**Subject: Exhibition of EIS - Yiribana Logistics Estate (SSD-10272349)**

## Attachment A – EES response to EIS for Yiribana Logistics Estate (SSD-10272349), 754-770 and 784-786 Mamre Road, Kemps Creek

Section A | Typical Streetscape Frontage Cross Section 1:150

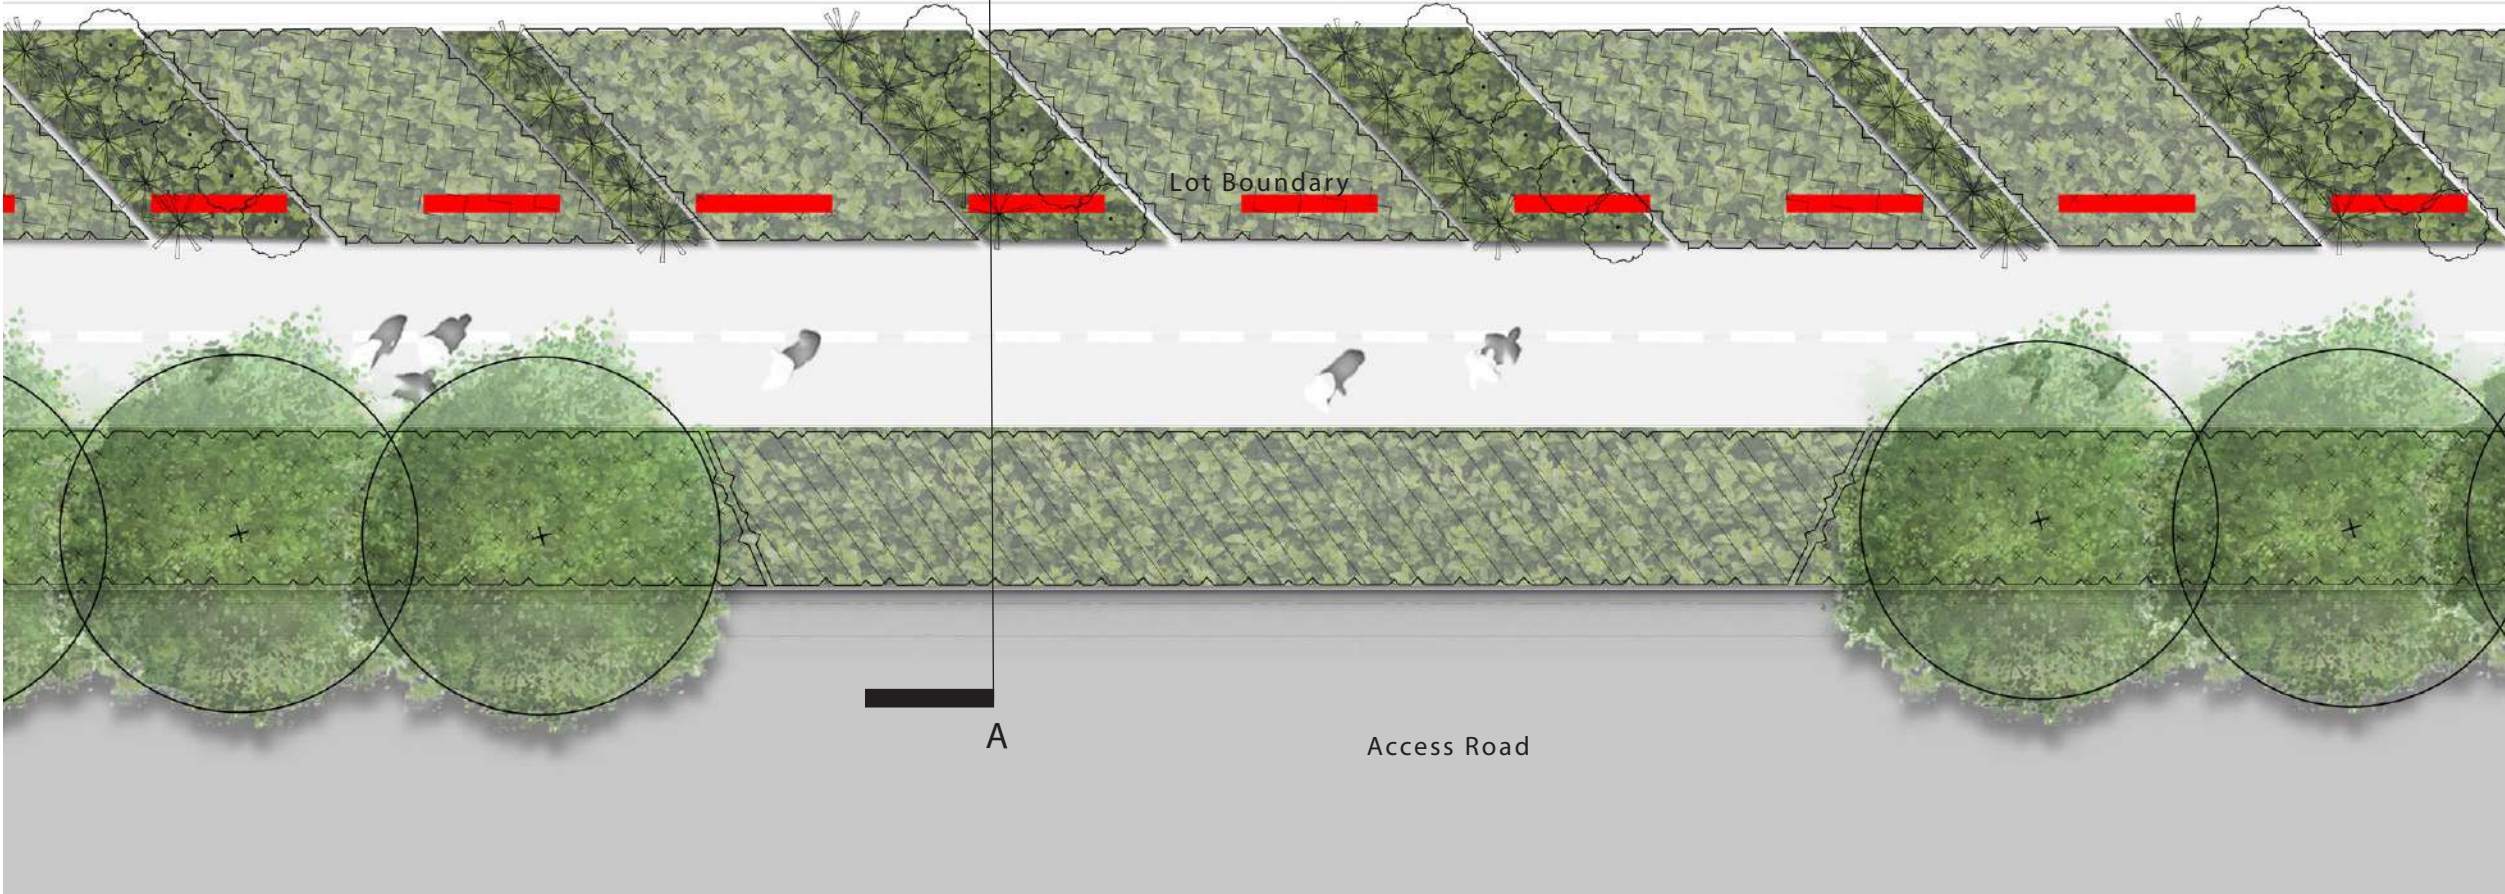
- In relation to Streetscape Planting, the landscape plan states '*Streetscape Frontages Mix of exotics say 30/70 with some turf areas seasonal variation in planting*'. EES preference is for the site landscaping to use local native plant species that once occurred on site rather than plant exotic or non-local natives except where additional benefits such as reduced heat island effects can be demonstrated from the use of these species. Priority weeds must not be used in any circumstances.

# Masterplan / Mamre Road Frontage

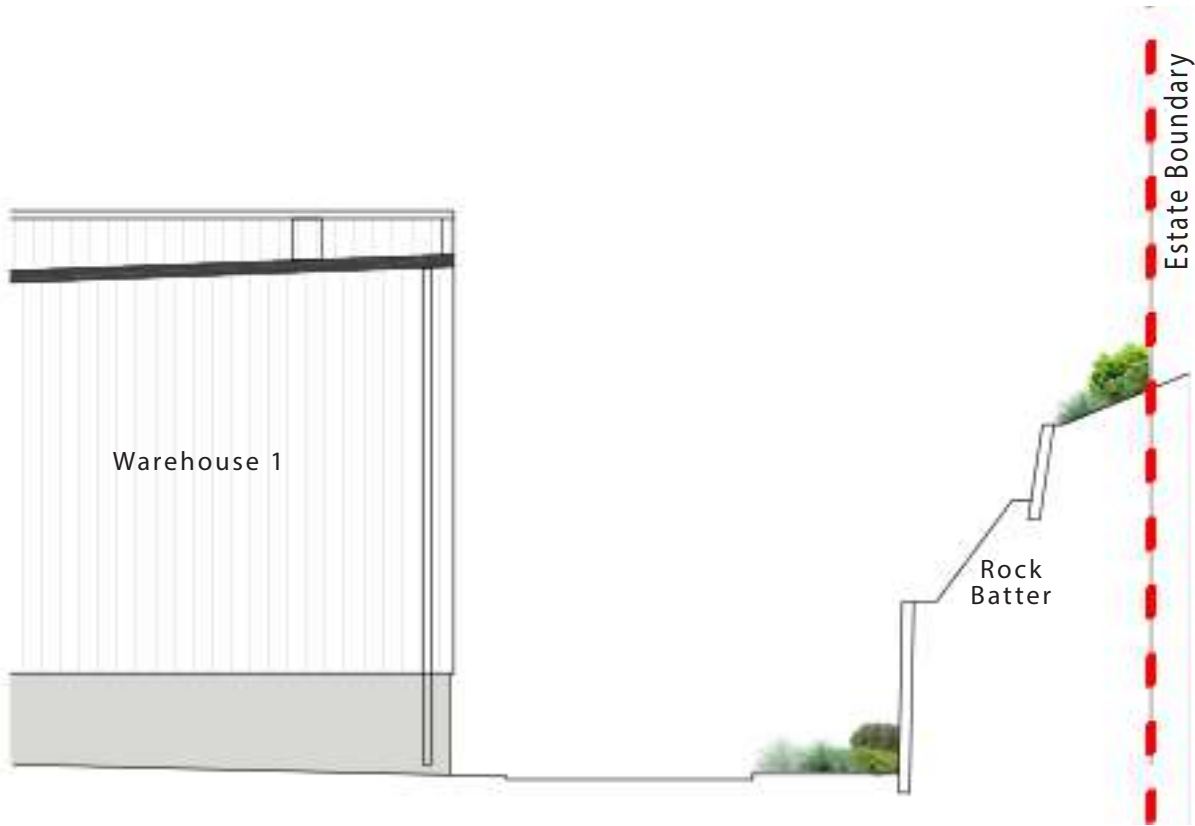
- The EIS identifies that a 10m landscape setback is proposed to Mamre road however It appears that that a substantial portion of this setback is occupied by proposed bio-retention basin which restricts the potential for replacement planting to mitigate the loss of trees from the proposed development. The actual extent of available landscape and planting space should be clarified along with a detailed planting plan and schedule for this area as mentioned above.

Stage 1 Masterplan /  
Landscape Stage 1 Masterplan

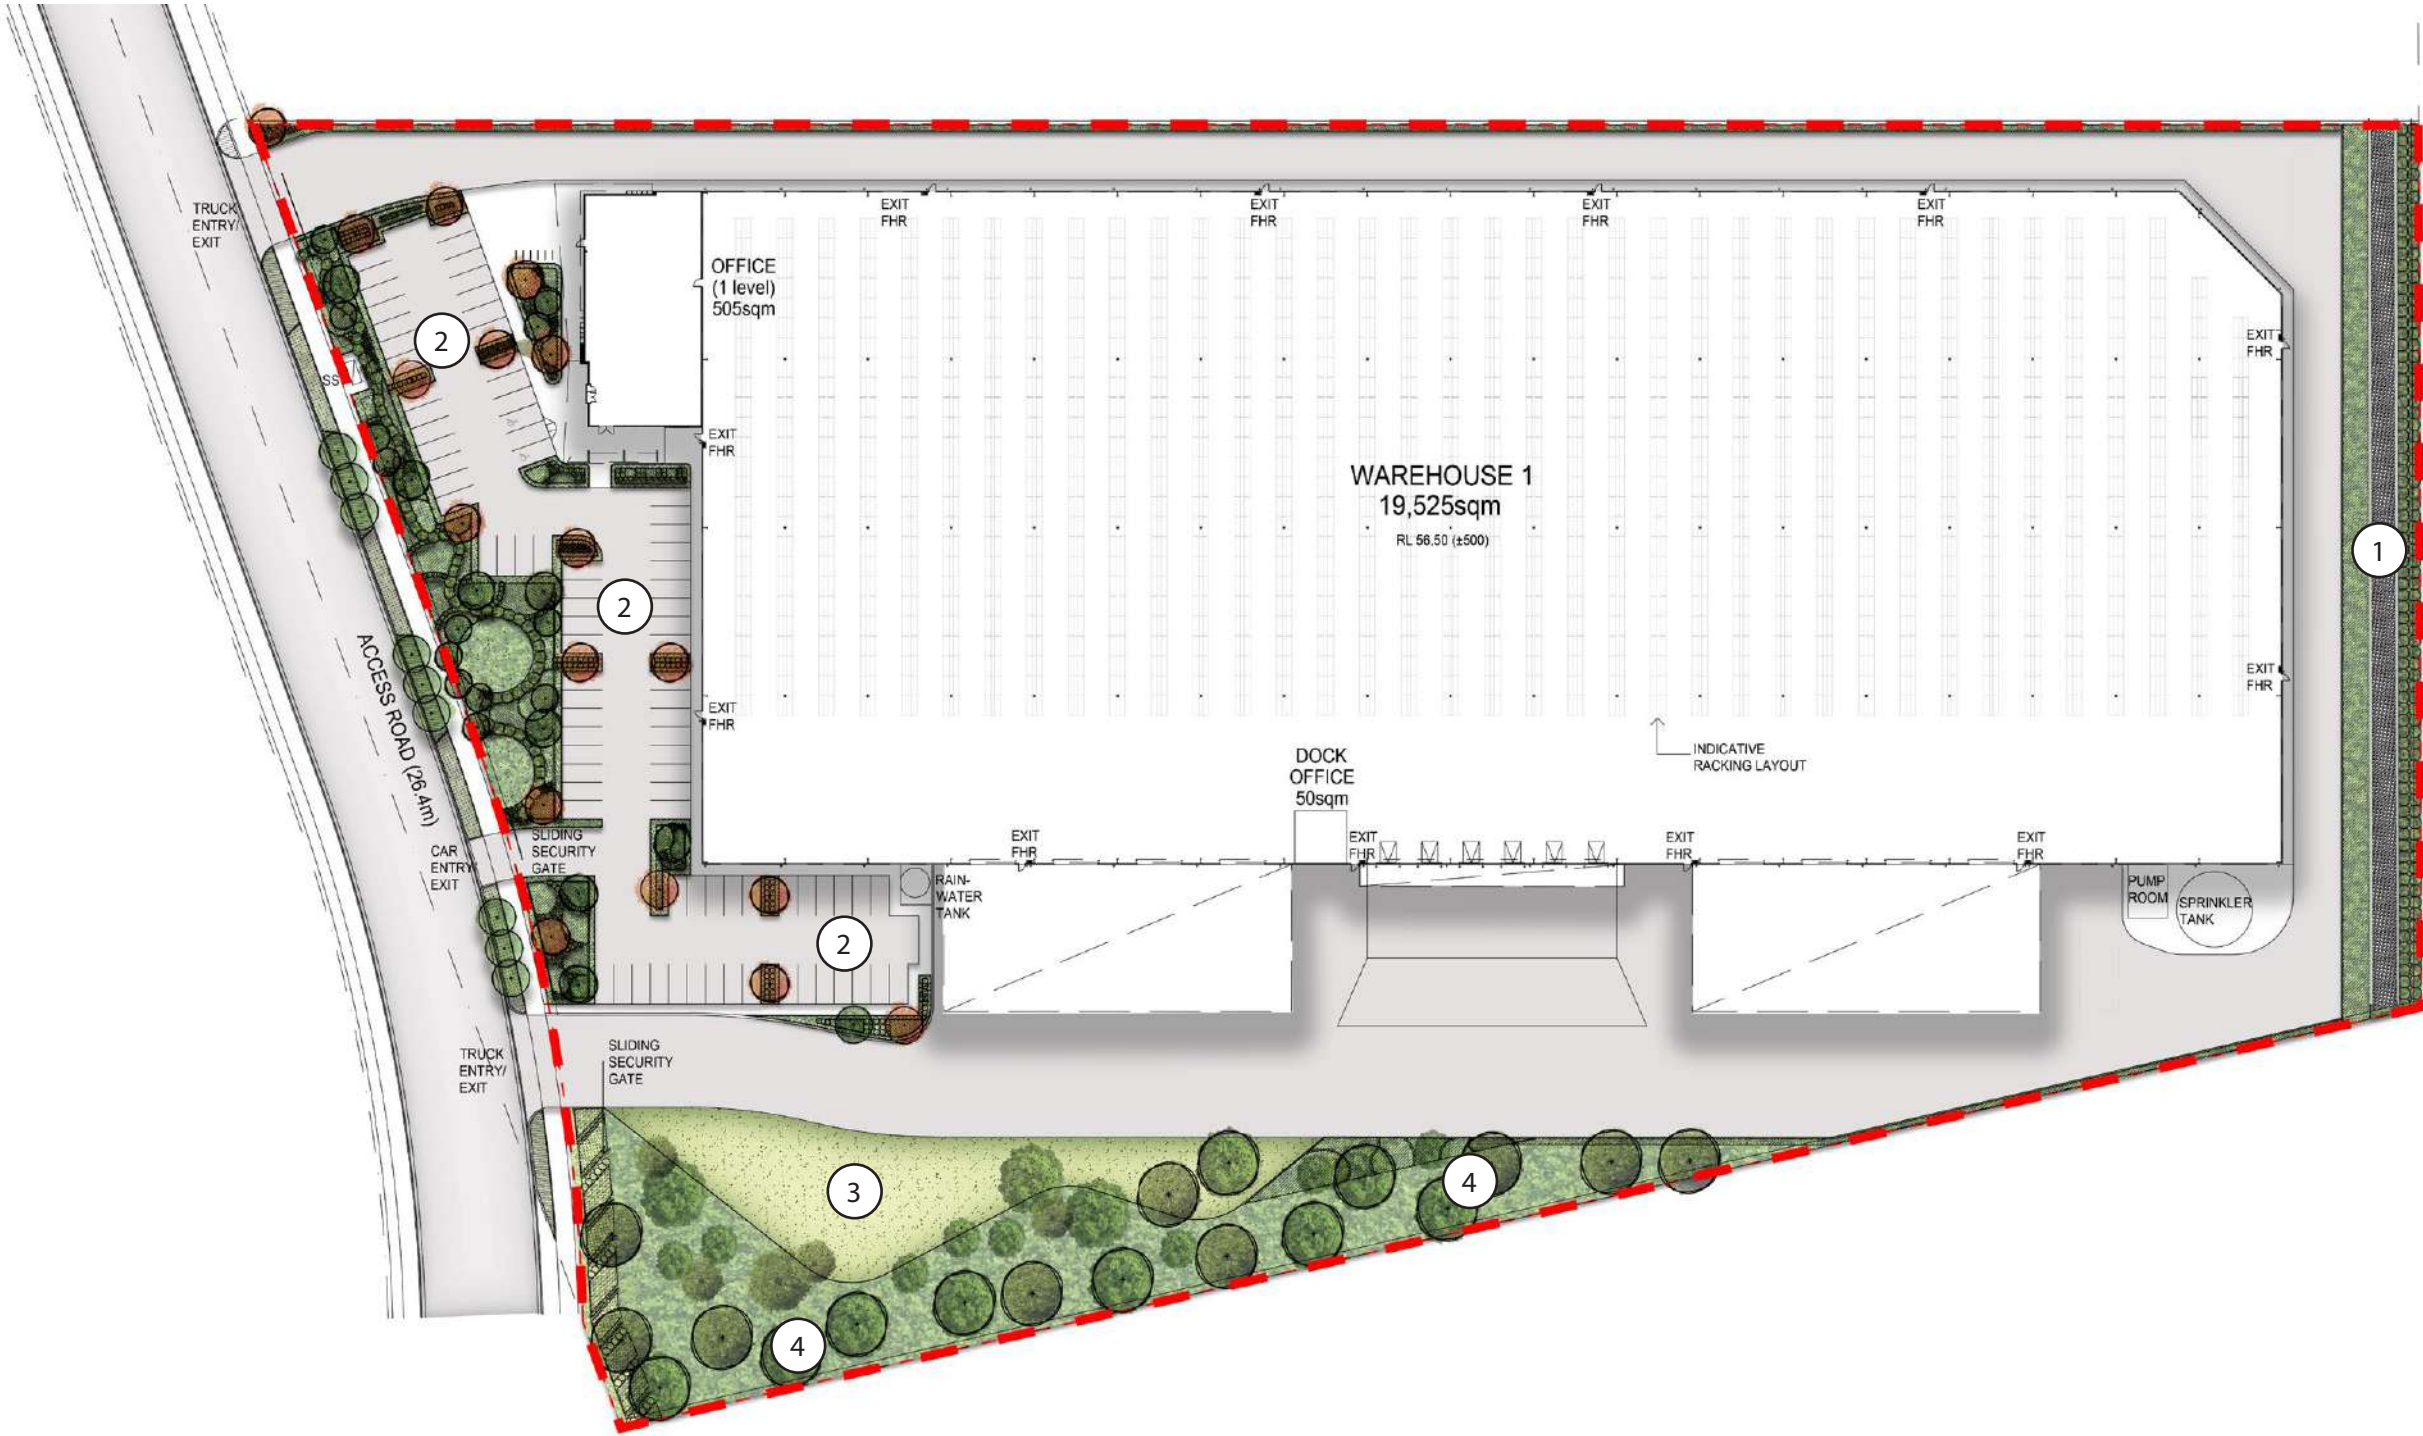
- The Landscape Masterplan prepared by site image (dated June 2021) does not include planting of canopy trees along the northern and eastern setbacks of proposed warehouse 3. Whilst it is acknowledged the required retaining walls will limit planting space, opportunity may exist for the use of small native canopy trees such as *Elaeocarpus reticulatus*, *Elaeocarpus eumundi*, *Ceratopetalum apetalum*, *Tristaniopsis laurina*, etc. in these locations.

- The planting schedules included in the landscape plan do not include essential details such as number of plants and proposed pot sizes. Detailed planting locations are also lacking from the plan. A detailed plant schedule and planting plan should be provided.
